KITTITAS COUNTY DEPARTMENT OF PUBLIC WORKS

MEMORANDUM

TO: Mackenzie Moynihan, Community Development Services
FROM: Christina Wollman, Planner II *cw*
DATE: September 17, 2008
SUBJECT: B&J Plat LP-08-21

B & J PLAT
PART OF SECTION 7, T. 17 N., R. 18 E., W.M.
KITTITAS COUNTY, WASHINGTON
- PRELIMINARY PLAT -

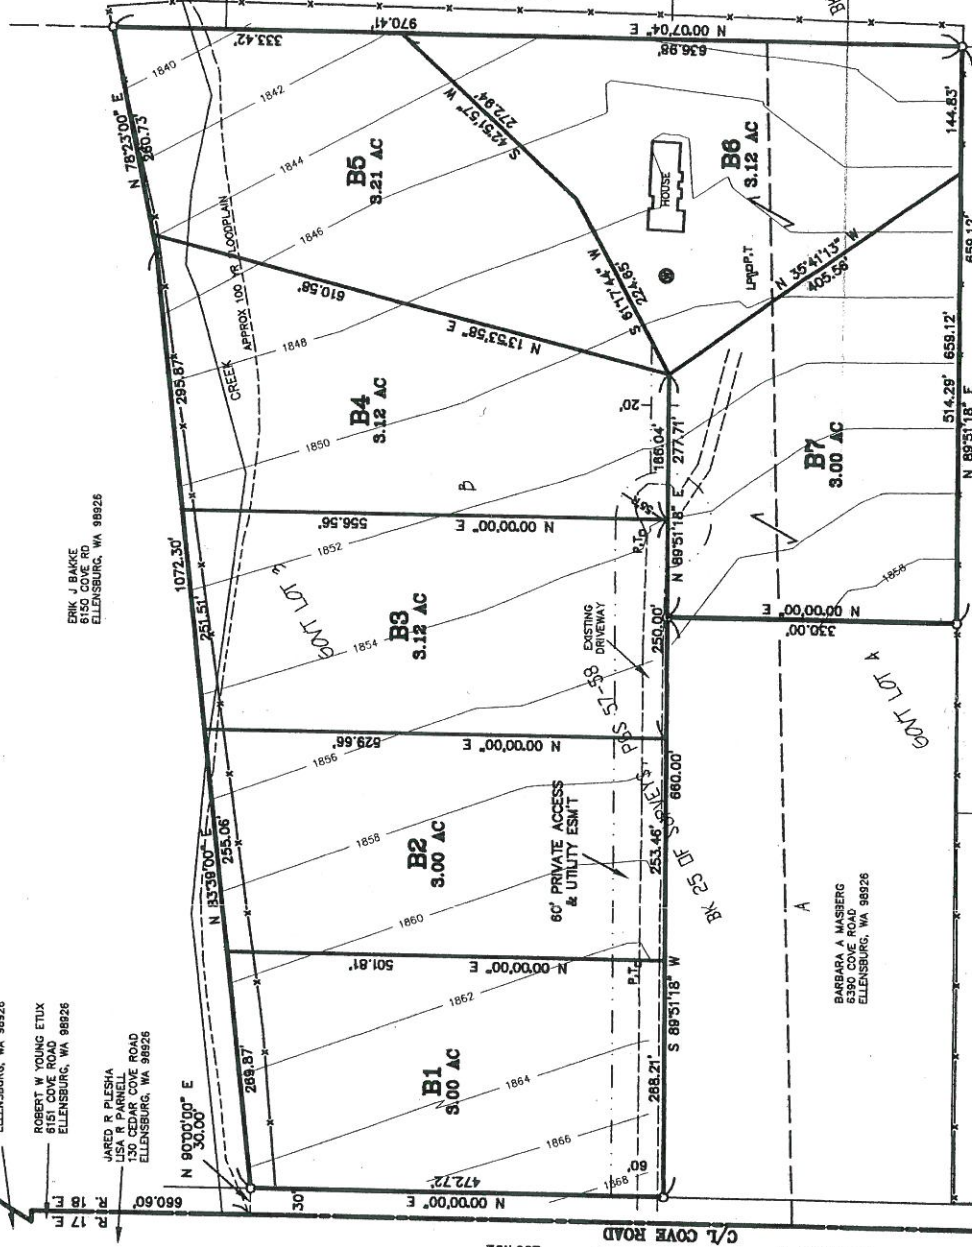
3. Private Road Improvements: Access from Cove Road to the cul-de-sac shall be constructed to meet or exceed the requirements of a High-Density Private Road that serves 3-14 tax parcels. See Kittitas County Road Standards, 9/6/05 edition.

- a. Access easements shall be a minimum of 40' wide. The roadway shall have a minimum width of 20', with 1' shoulders, for a total width of 22'.
 - b. Minimum centerline radius will be 60'.

- c. Surface requirement is for a minimum gravel surface depth of 6".
 - d. Maximum grade 8% flat, 12% rolling or mountainous.
 - e. Stopping site distance, reference AASHTO.

4. Cul-de-Sac: A cul-de-sac turn-around having an outside right-of-way easement diameter of at least 110 feet shall be constructed at the closed end of all dead-end roads serving 3 or more lots. The driving surface shall be at least 96 feet in diameter. Cul-de-sacs must also conform to the requirements specified by the 2006 International Fire Code. Contact the Fire Marshal regarding any additional cul-de-sac requirements.
